Recommendation Report for Planning Permission for Works or Extension to a Dwelling

REF NO: FP/206/19/HH

LOCATION: 36 Sea Drive
Felpham
PO22 7NB

PROPOSAL: Two storey front extension and replacement single storey rear extension. New Solar panels to South & West roof elevation.

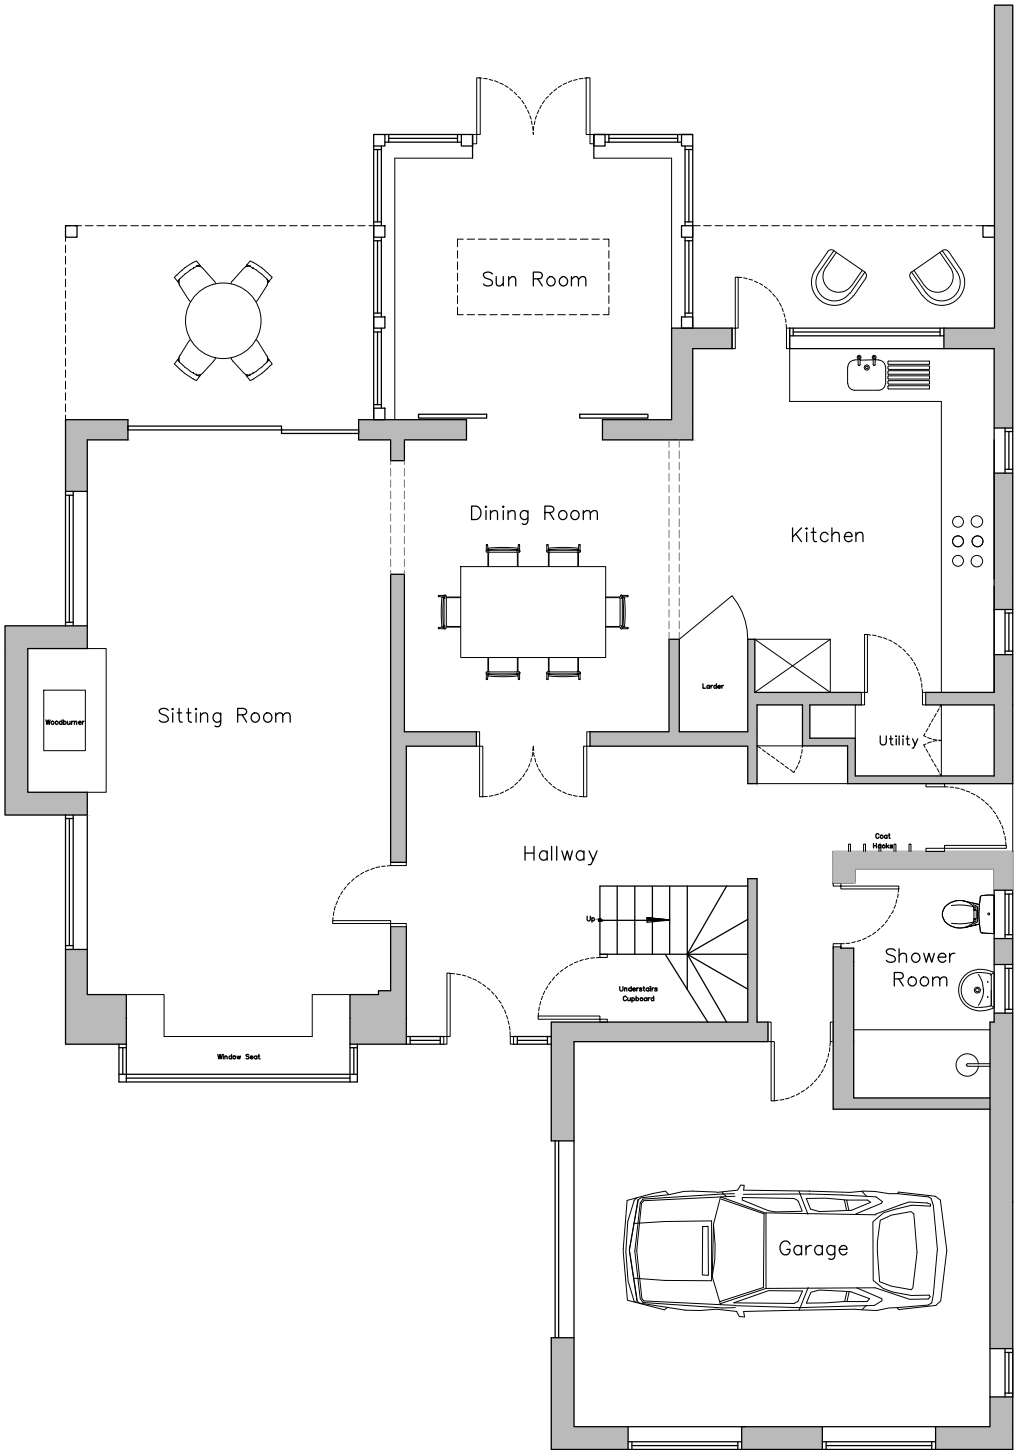
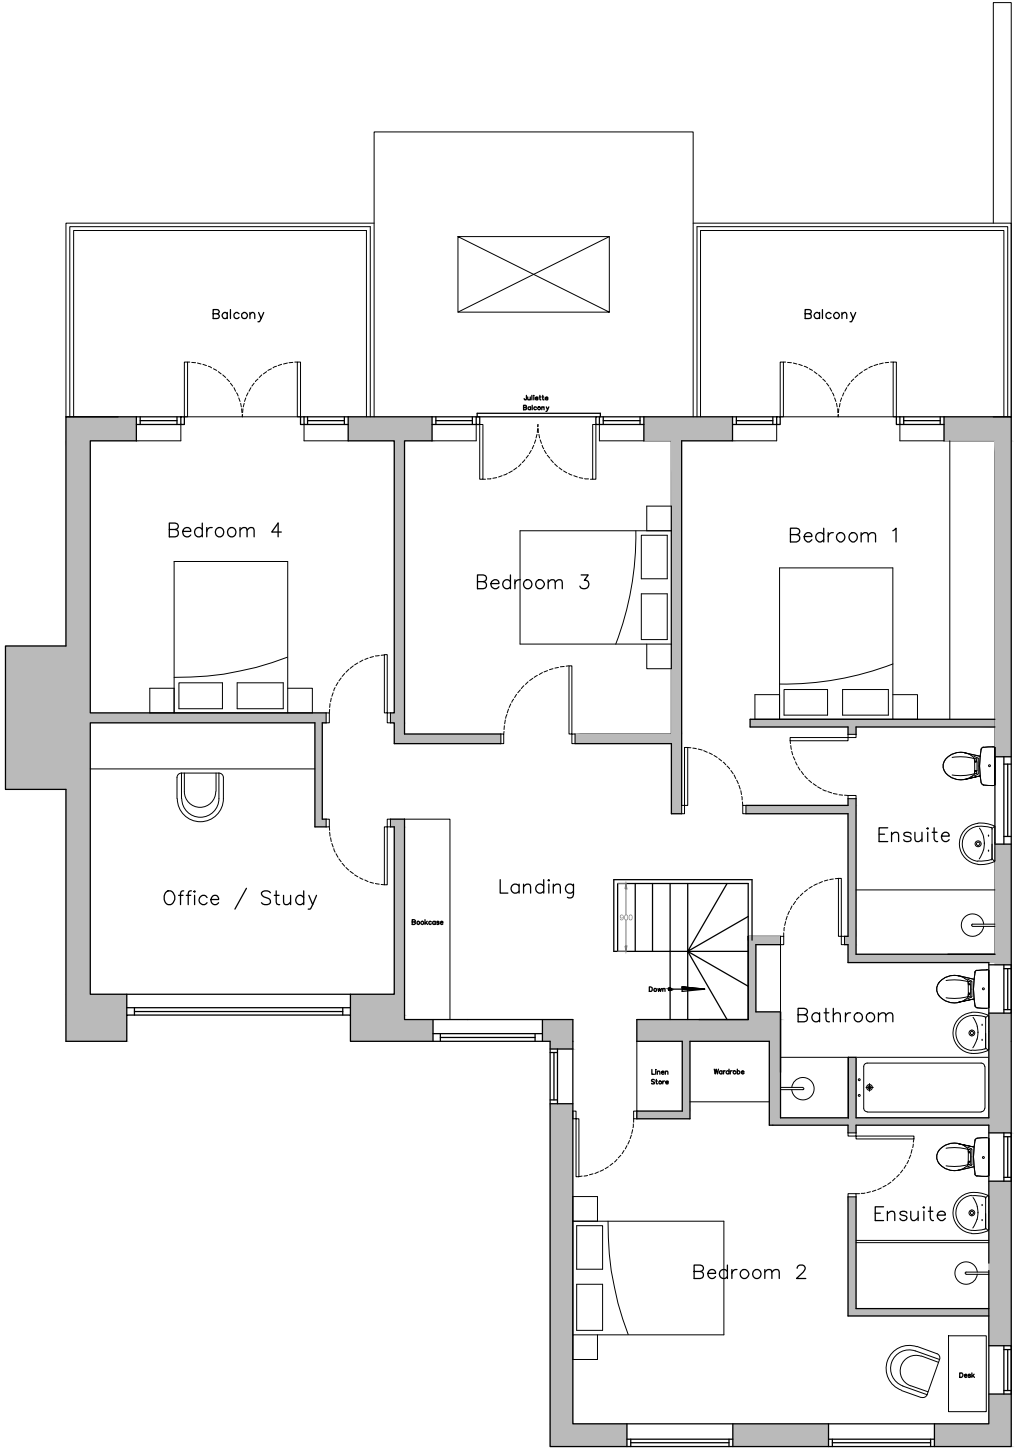
- 3 The bathroom/en-suite windows at first floor level in the Western elevation of the building shall at all times be and remain glazed entirely with obscure glass.

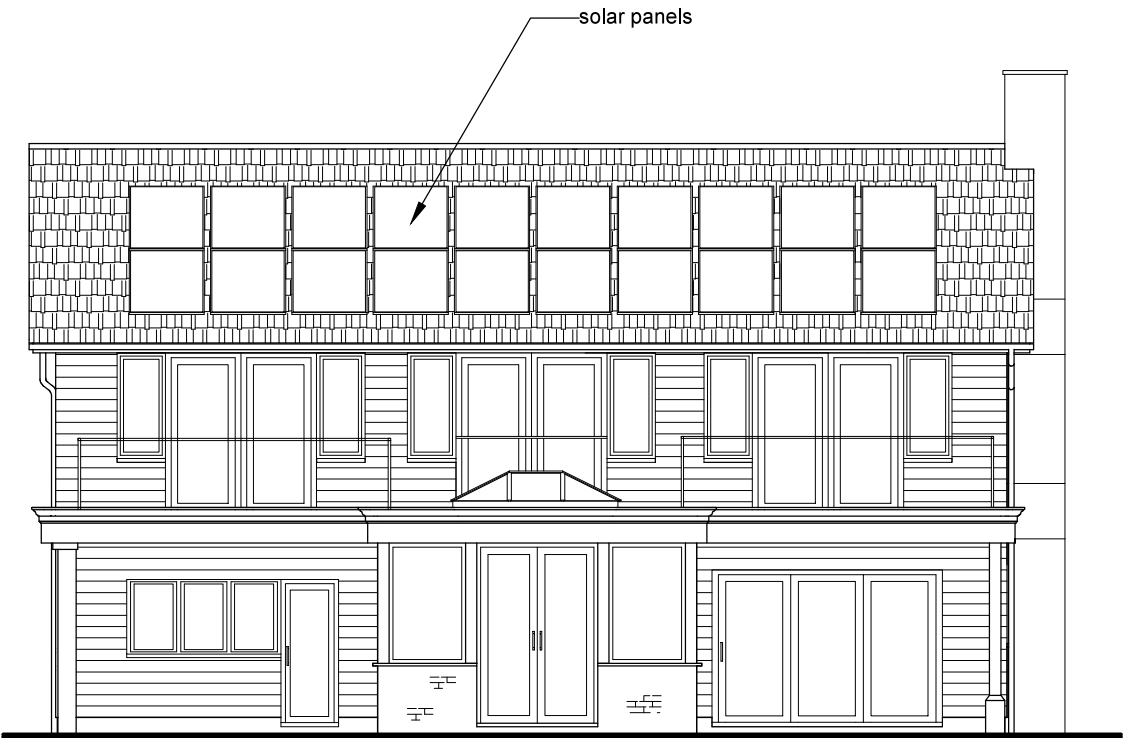
Whilst the main windows and the balconies overlook the rear garden the separation distance to the rear boundary and boundary treatment it is not considered the proposal will be unacceptably harmful to the occupiers of the properties to the east and west the potential detrimental overlooking from the side of the proposed balconies has been counteracted through the use of a condition ensuring there are screens to the east and west.

- 4 The east and western elevations of the balcony at first floor level, shall at all times be obscured to a height of 1.7m with fixed obscured glass and said screening shall be retained in perpetuity not withstanding those shown in the plan 10162-DPA-06.

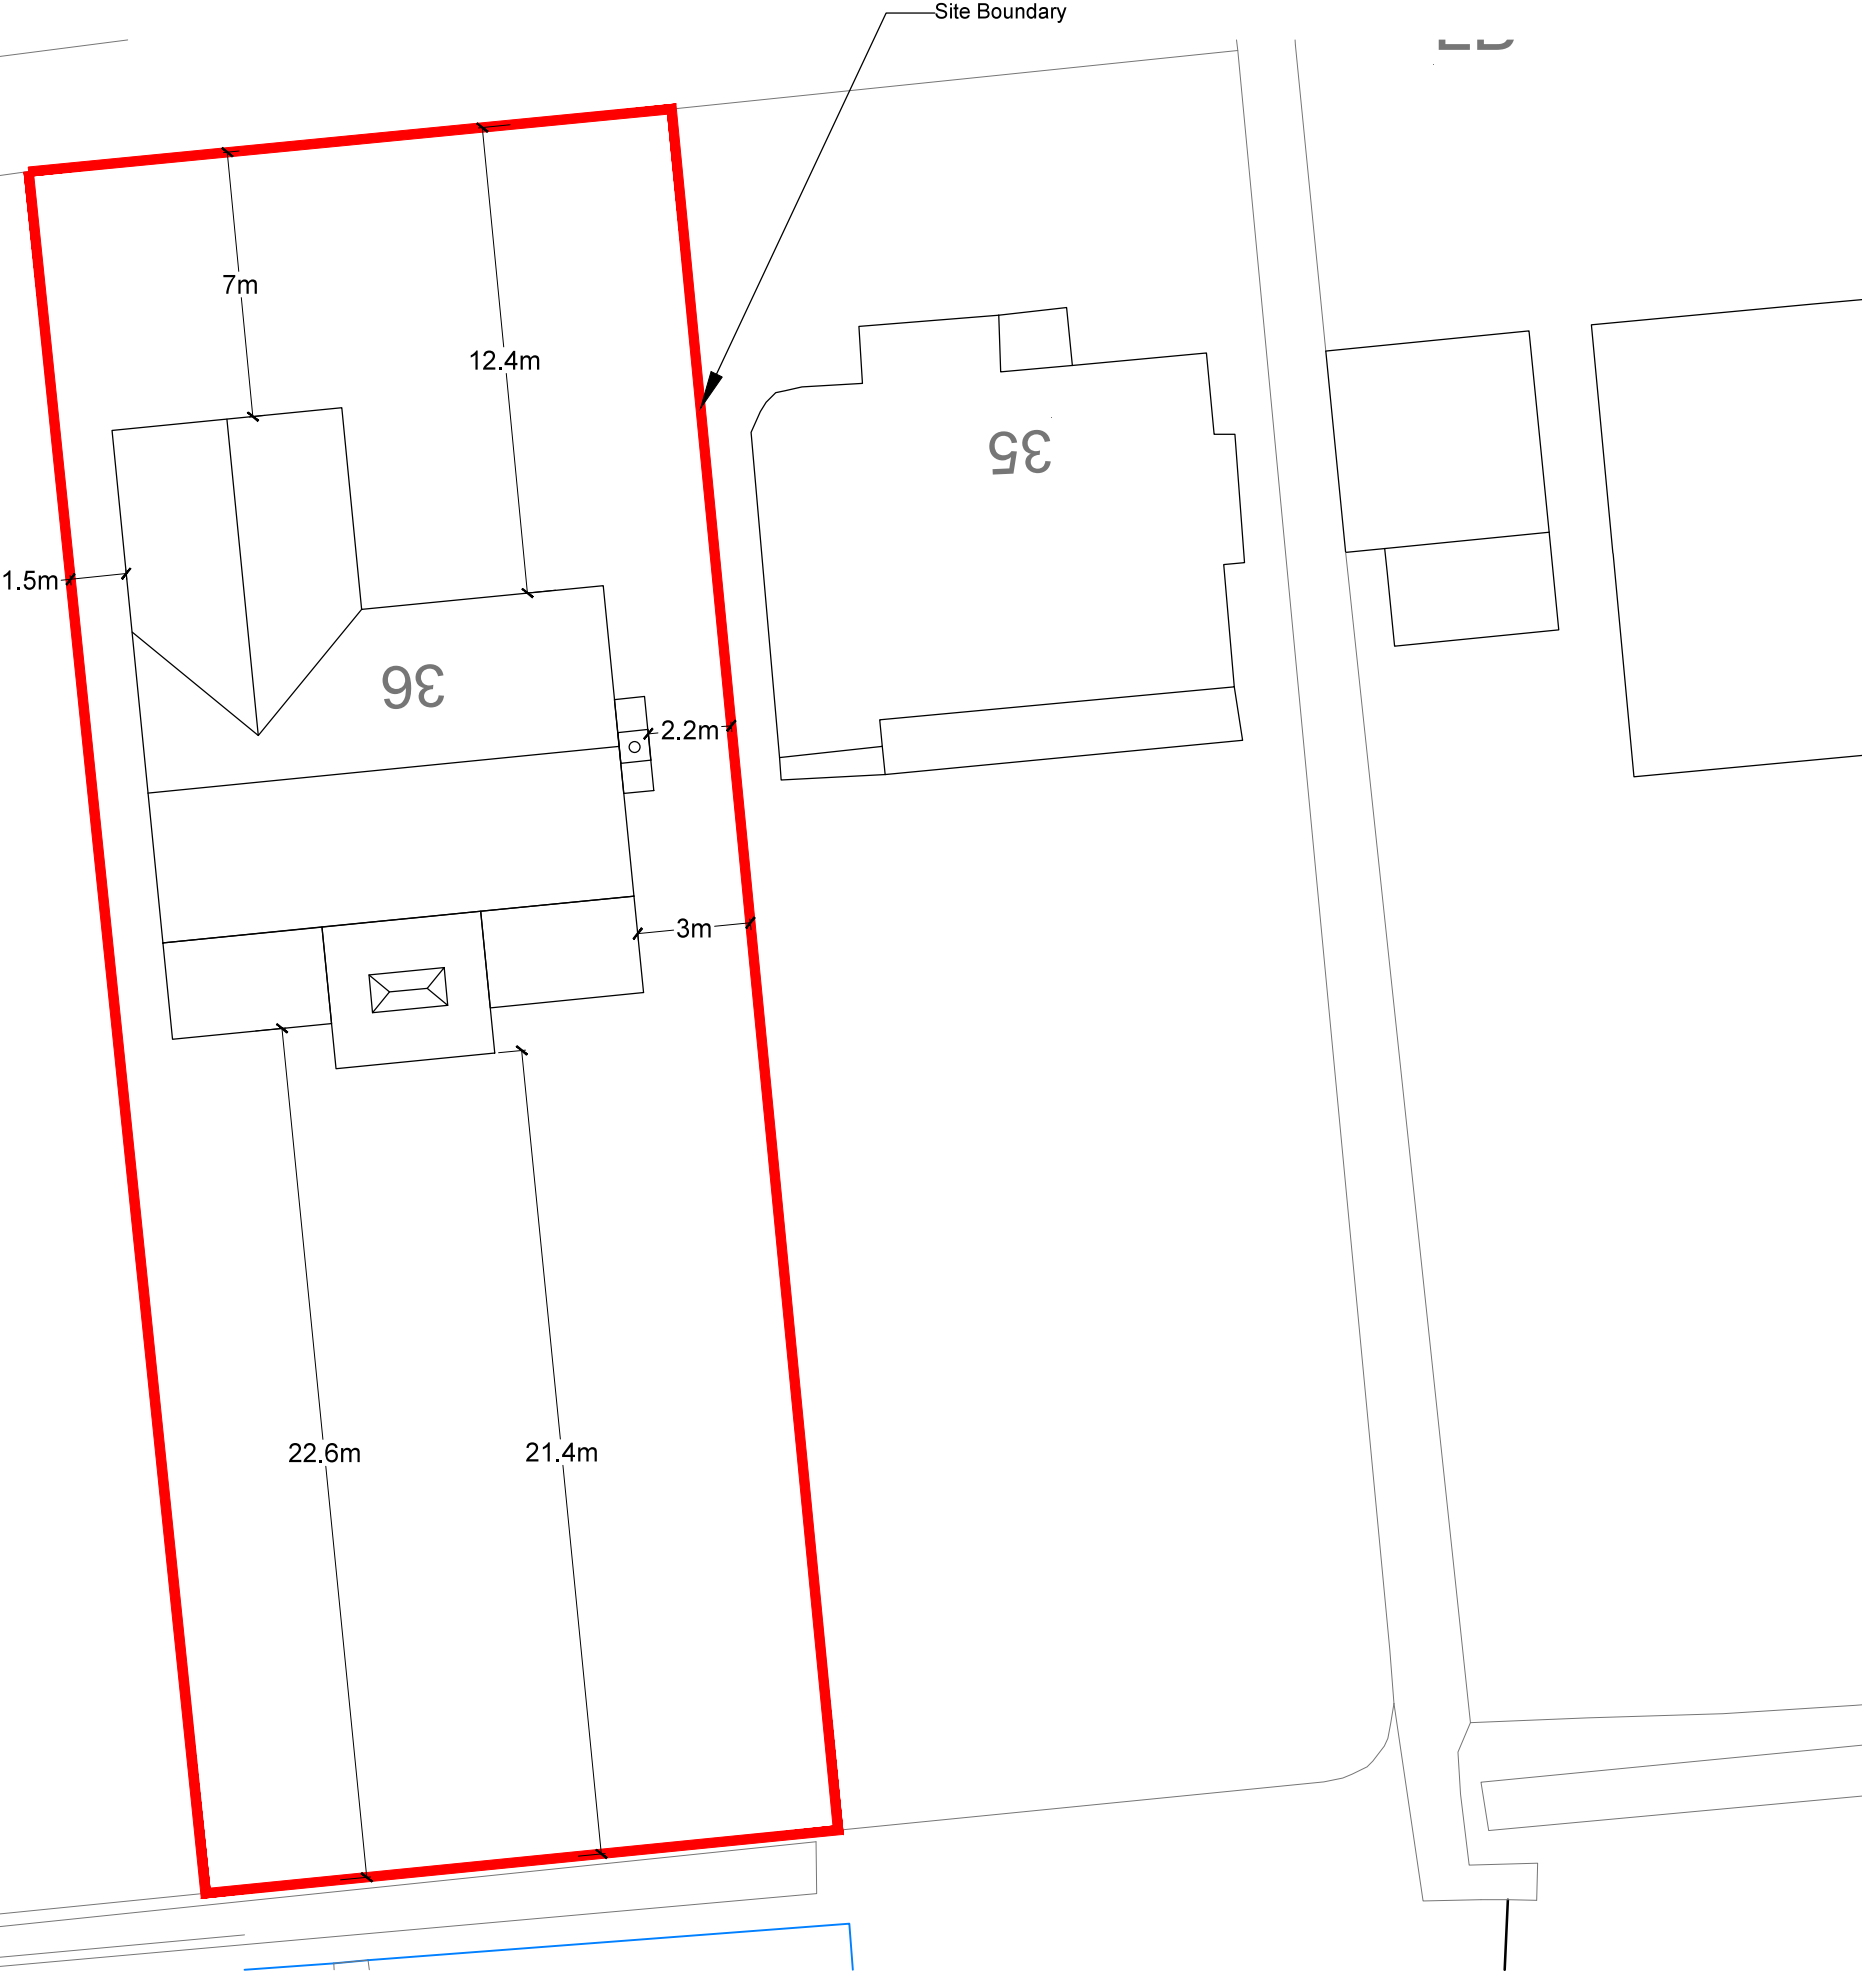
The two storey extension has been designed to be set down below the height of main roof, with a double pitch roof. The proposed two storey extension is not the full width of the front elevation measuring 6.25m on the western edge of the property it protrudes 5.2m to the north. On the east of the proposed two storey elevation there is set to be 6.4m to the edge of the property. The proposed extension would be set in approximately 7m from the northern boundary fronting the road and 21.4m from the southern boundary fronting the beach thereby retaining a significant amount of garden area. The proposed extension would be visible from the road. However, due to its design it is sufficiently well integrated with the appearance of the host dwelling. Additionally, there are examples of similar development within the locality, which is considered to allow the proposal to have no significantly harmful impact upon the character of the locality. Given the size of the property and the plot it is considered that the proposed extension would be subservient to the main house.

The proposed extension would be sited approximately 1.5m from the side boundary to the west and approximately 22m from the dwelling itself. There are side windows on the front extension facing No.37 however due to the distance and expansive ground they are not considered to gain an unacceptable level of overlooking however, due to the use of the rooms the windows served they will be conditioned to be obscure glazed. Therefore, together with the depth and height of the extension it is not considered that the proposed development will be harmful to the residential amenity of the occupiers of No.37. With regard to No.35 the proposed rear extension is set in approximately 3m from the side boundary and the new chimney will be located 2.2m from the eastern boundary it is understood that this is not part of the
